SUBJECT: Engineering Review Comment
Mountain View Electric Association Inc. (MVEA)

Project Name: Greaves Subdivision Filing 1 – Vacation Replat
Project Number: VR243

Description: A proposed development of 2 lots located at 7030 Snow Mass Dr. east of Black Forest Rd. in Township 12S, Range 65W, Section 05.

## GREAVES SUBDIVISION FINAL PLAT

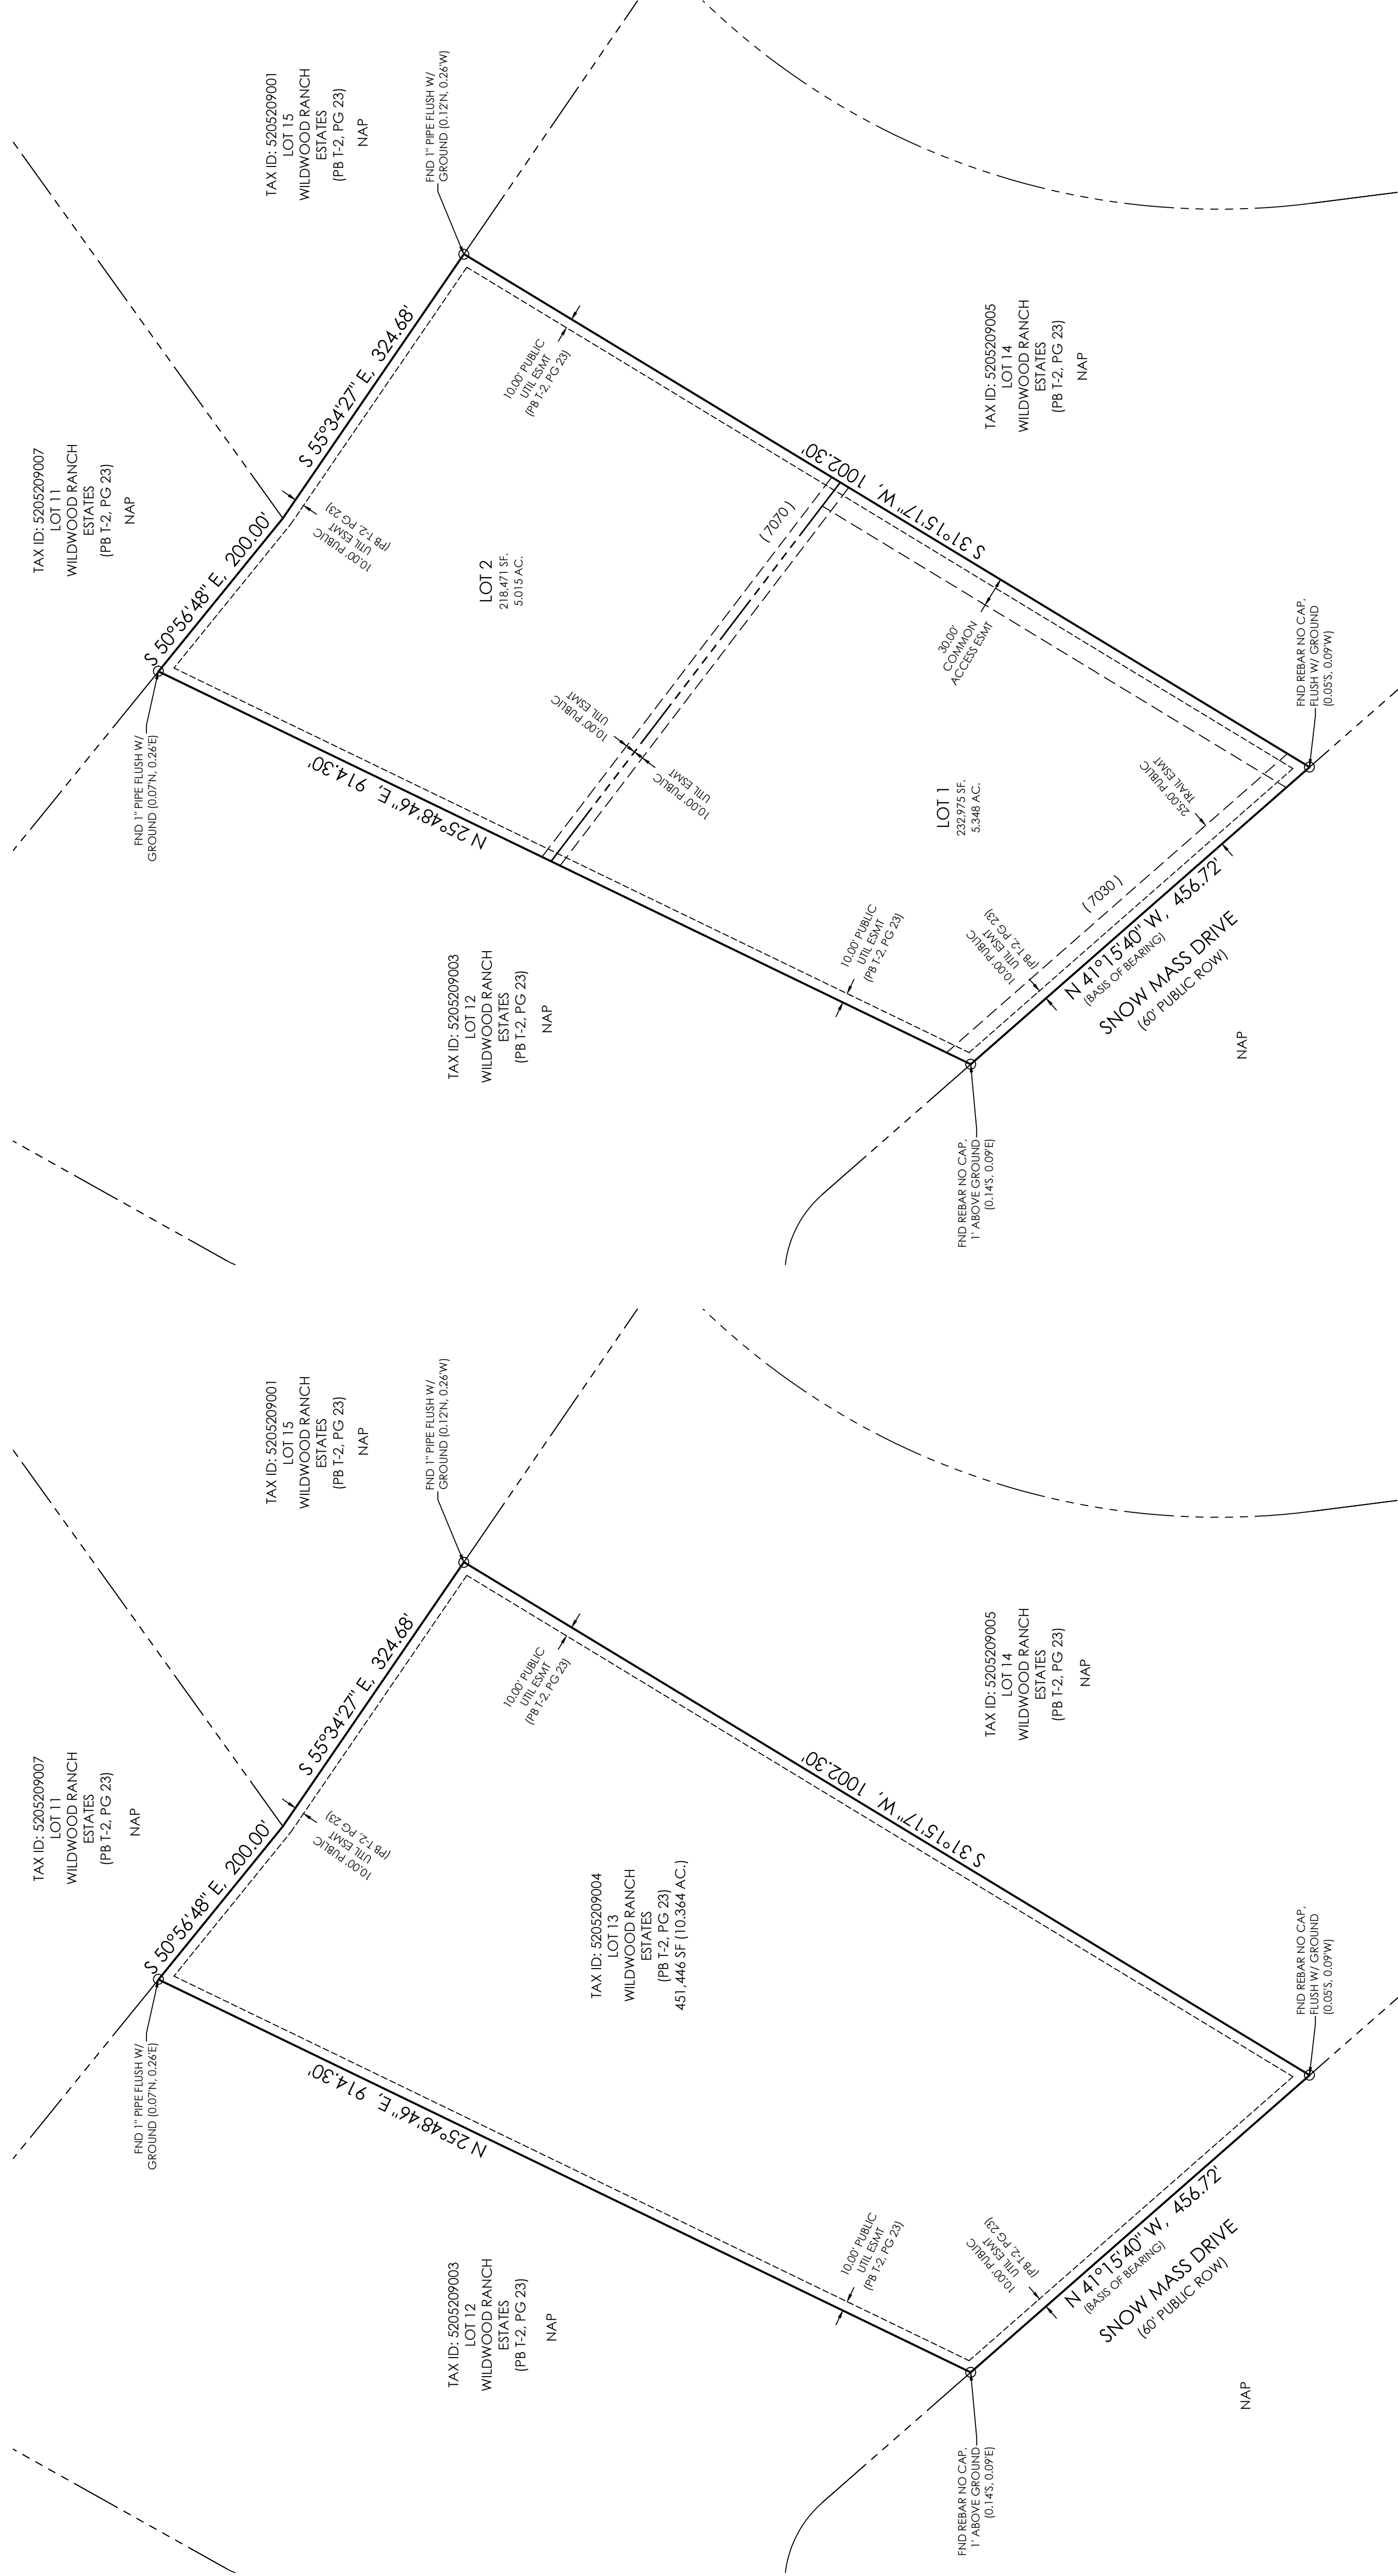
MVEA requests a ten (10) foot front, side, and rear lot utility easement and all tracts, along with a twenty (20) foot exterior utility easement on the plat. MVEA also requests the platting of MVEA's existing facilities with easements on the plat. Additional easements may be required.
